# East Anglia ONE North and East Anglia TWO Offshore Windfarms

## Applicants' Responses to Examining Authority's Written Questions 3

### Volume 9 – 3.14 Other Projects and Proposals

Document Reference: ExA.WQ-3.D10.V1\_09

Drawing file: EN010078 / EN010078-004511-ExA.AS-31.D8.V1 02 EA1N&EA2 Photomontages with Potential National Grid Extensions Bays Figure 29.17 VP5.pdf

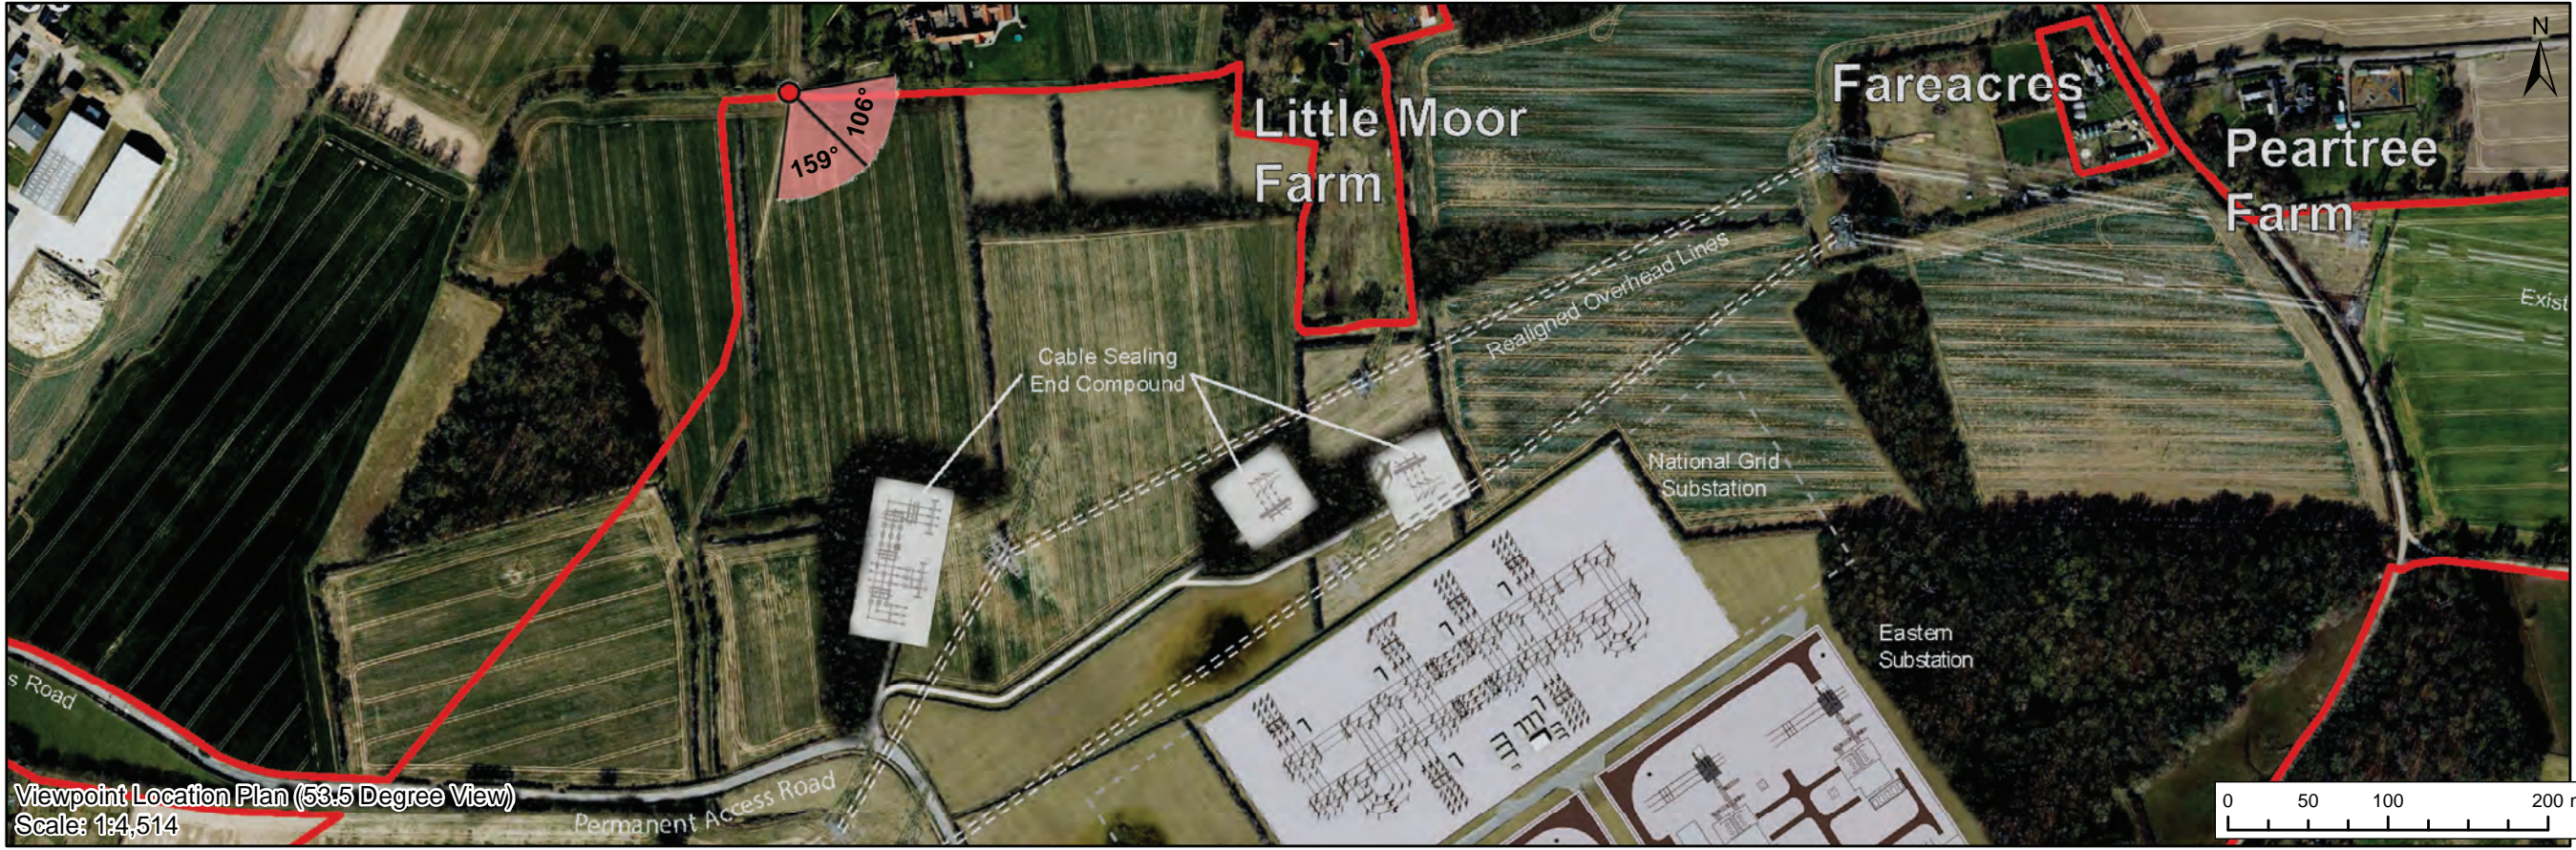
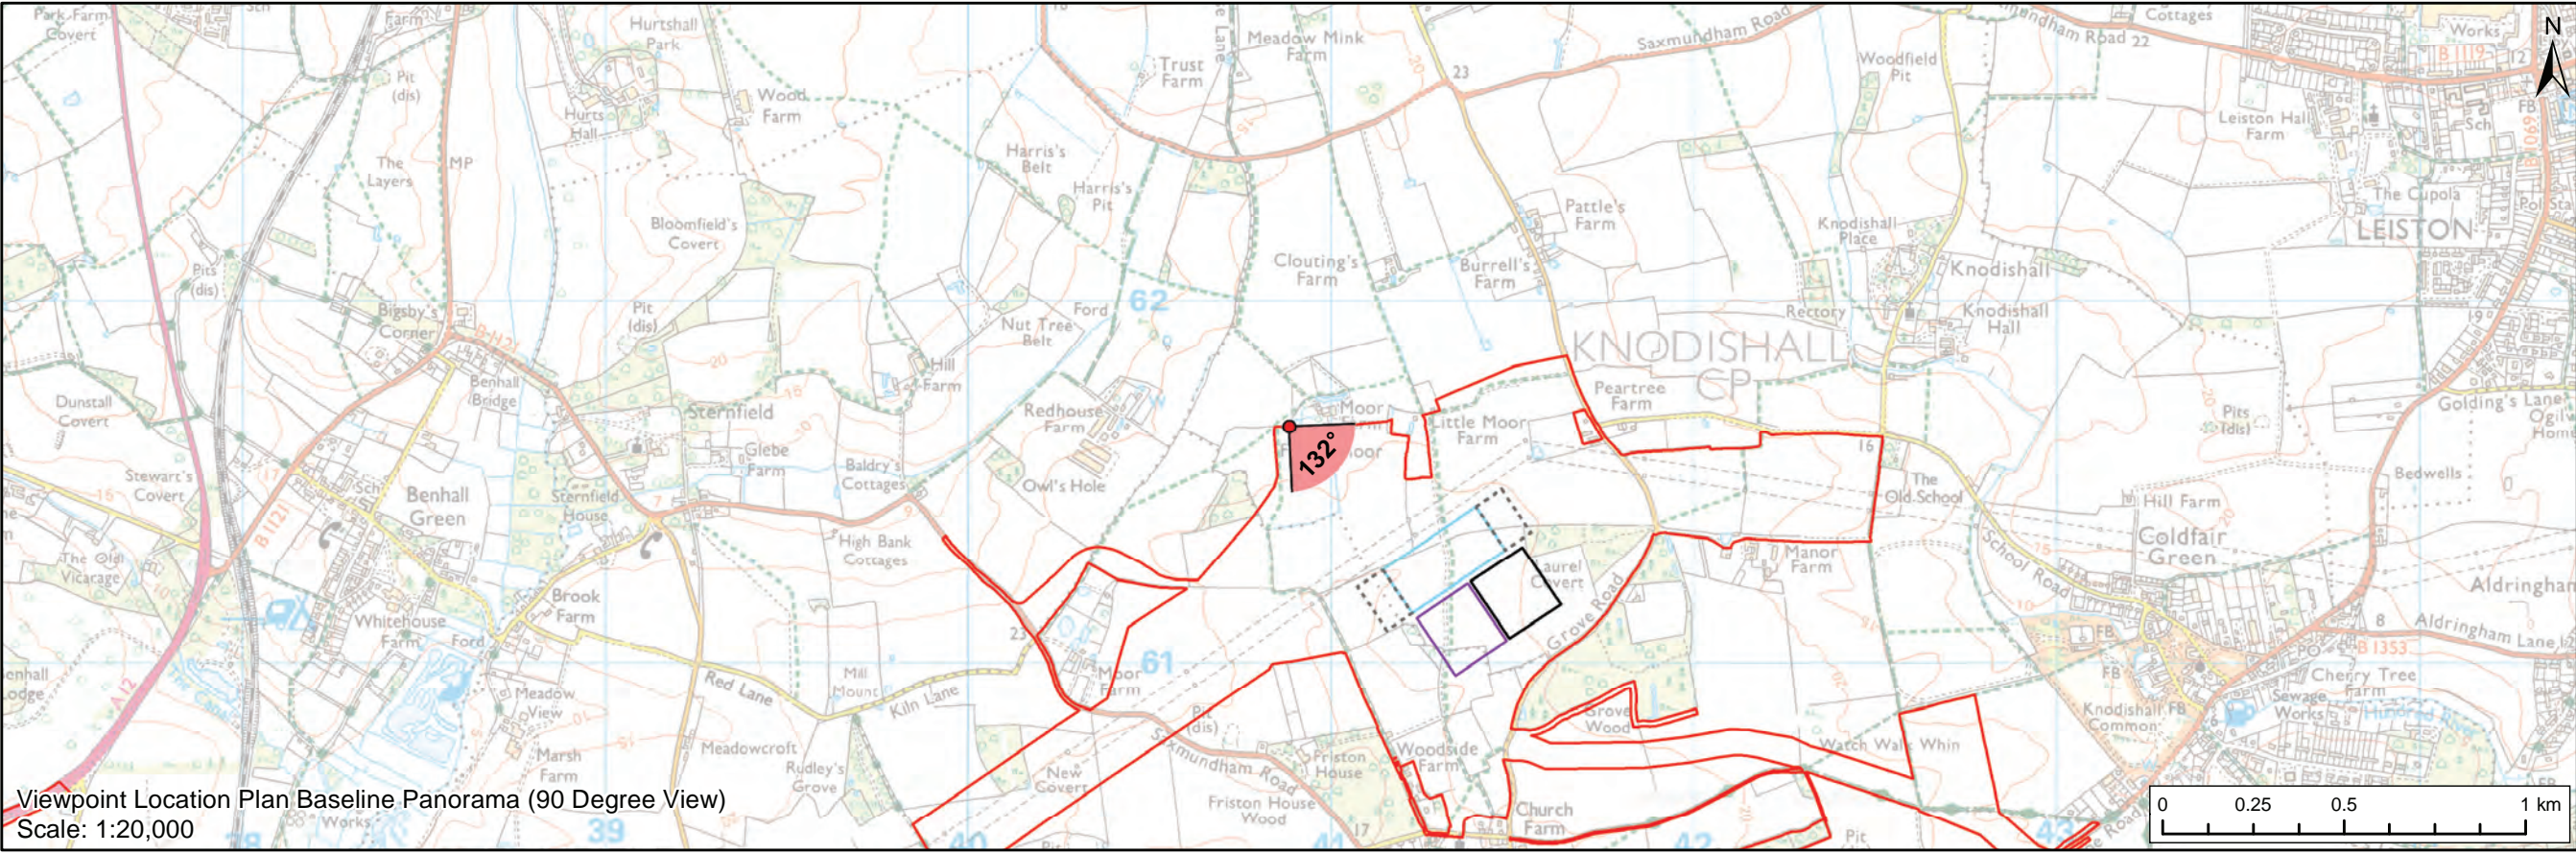
ExA. Question Ref.	Question addressed to	ExA. Question	Applicants' Response
		<p>amount of electrical equipment. Given this and the proximity of this viewpoint to the southern boundary of High House Farm (and given recent reductions to woodland cover of this property) do you still consider that adverse impact for this heritage asset would remain of a low magnitude?</p>	<p>the degree of change (including cumulative change) does not directly lead to conclusions regarding impact on significance. It is necessary to consider both the extent to which views looking north from Church Road are part of the positive contribution that setting makes to the significance of the church, and then also factor in the degree to which the significance of the church as a whole resides in its setting.</p> <p>Considering the case of the Church of St Mary, Friston, the significance of this asset has been described in Environmental Statement (ES) Appendix 24.7 (REP-519, paras 91-94). There, it is noted that "<i>The significance of this asset (and the reason for its designation as a Grade II* Listed Building) primarily lies in the medieval fabric of the church</i>". The analysis goes on to note that "<i>Setting contributes to the significance of this church on three different scales</i>" and then provides further details.</p> <p>The view north from Church Road, illustrated as Viewpoint 2, is an example of a view in the immediate setting of the church but, it should be noted, it is not a view of the church nor a view from within the churchyard.</p> <p>It is acknowledged that t the predicted additional visual change at Viewpoint 2 would lead to some further erosion of the rural character of the setting, this would not materially affect the assessment of impact on the significance of the church; there would therefore be no material change to the cumulative impact.</p> <p>Turning to Viewpoint 5 and its relevance to an assessment of impacts on High House Farm, the Applicants have always</p>

ExA. Question Ref.	Question addressed to	ExA. Question	Applicants' Response
			<p>recognised that the substations collectively would result in considerable change to landscape character in the setting of this Listed Building. Quoting from ES Appendix 24.7 (para 63) with reference to CHVP3 and Viewpoint 5:</p> <p><i>“Together, these two photomontages illustrate how views looking southeast in the setting of High House Farm would be changed from a predominantly rural agricultural character (albeit with existing pylons) to a mix of industrial infrastructure and rural agriculture. In all three scenarios the highest structural elements are in the National Grid Substation and cable sealing end compounds; these would be seen in front of the two other onshore substations, but both would be clearly visible beyond them. Therefore, although there are differences in the precise nature of the visual change, the overall level of change in the setting of High House Farm would be essentially the same for all three operational arrangements.”</i></p> <p>Subsequently, in the <b>Extension of National Grid Substation Appraisal</b> (REP8-074), it was recognised that there would be a limited increase in impact on the significance of High House Farm as a result of extensions to the National Grid Substation:</p> <p><i>“Cumulative change in the settings of Little Moor Farm, High House Farm and Woodside Farmhouse would marginally increase the change in landscape character and therefore the resulting impact on significance of these assets. However, this would not be sufficient to change the assessment findings which would remain adverse impacts of medium</i></p>

ExA. Question Ref.	Question addressed to		ExA. Question	Applicants' Response
				<p><i>magnitude for Little Moor Farm and low magnitude for High House Farm and Woodside Farmhouse.</i> “</p> <p>This conclusion reflects the fact that the substation infrastructure was already highly visible in this part of the setting and therefore the additional impact of the extensions would be more limited.</p> <p>Recent reductions in woodland cover in the garden of High House Farm do not affect this assessment as the reduction does not materially change the way that this Listed Building relates to its setting in the round. It is acknowledged that this factor would be relevant to a visual impact assessment.</p>

Drawing file: published-documents / EN010078-004510-ExA.AS-31.D8.V1 01 EA1N&EA2 Photomontages with Potential National Grid Extensions Bays Figure 29.14 VP2.pdf

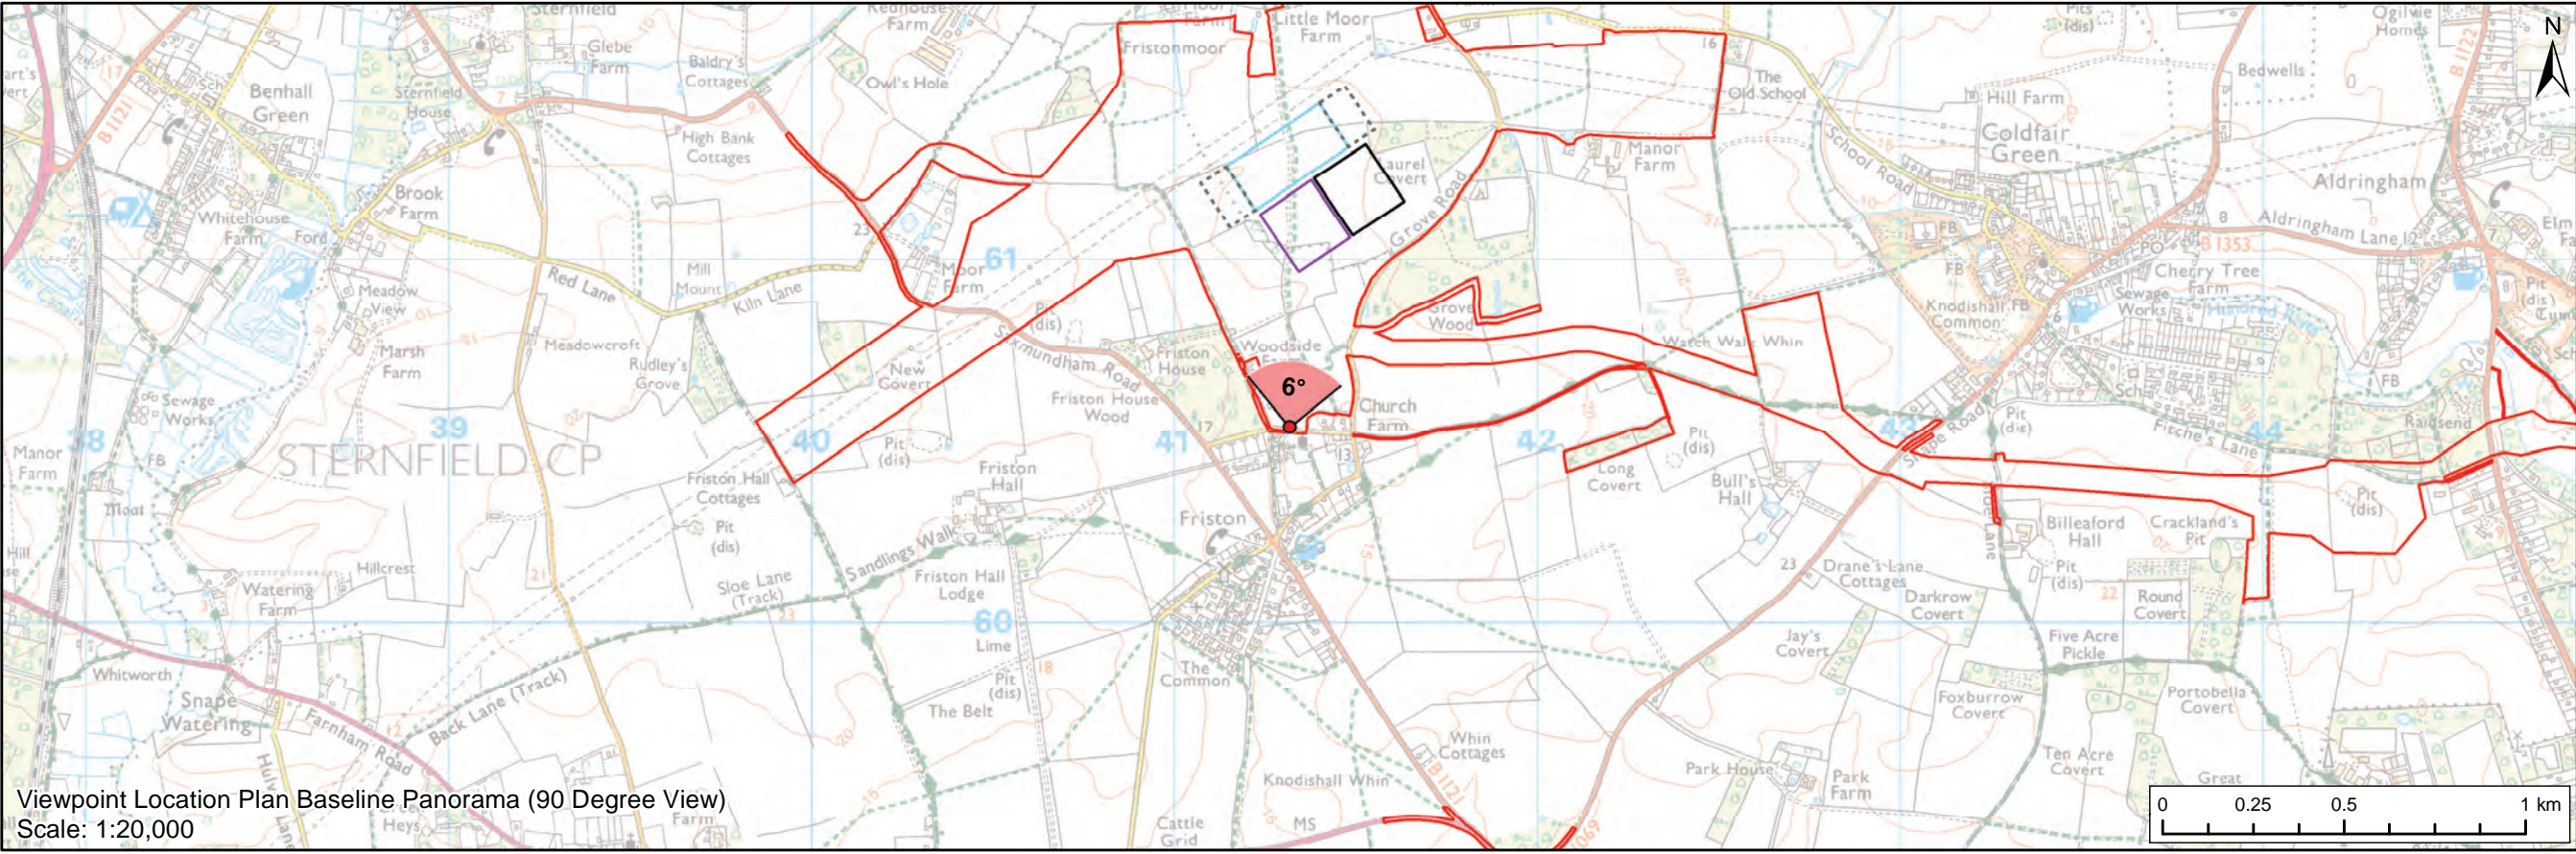
3.14.4	The Applicants		<p><b>Extension of National Grid Substation Appraisal – Photomontages</b></p> <p>a) The proposed viewpoint 2 [REP8-071] for the above appraisal (Friston, Church Road) indicates that the National Grid substation with extension bays, when combined with the two SPR substations would fill much of the viewpoint horizon, with the western extension bay remaining fairly visible after 15 years. Given this do you maintain that this level of change would not result in any cumulative impact on the significance of the Church of St Mary?</p> <p>b) Viewpoint 5 (Public Right of Way, near Moor Farm) [REP8-072] demonstrates that at year 15 the western half of the view would have a clear aspect of a substantial</p>	<p>The Applicants have previously addressed this point in the <b><i>Extension of National Grid Substation Appraisal</i></b> (REP8-074, paras 45 and 47) and still rely on the cumulative impact assessment presented there.</p> <p>Viewpoint 2 illustrates how the National Grid Substation extensions could be visible when standing on the north side of Church Road, beyond Friston churchyard. It is agreed that the upper parts of the western extension bay would be visible beyond existing hedgerows and that the highest parts would still be visible after 15 years growth of mitigation planting.</p> <p>It is important, at this point, to remember that cultural heritage impact assessment involving change in setting is based on an understanding of the significance of an asset and on how setting contributes to that significance in the round. It is not a viewpoint-based assessment of visual change and therefore</p>
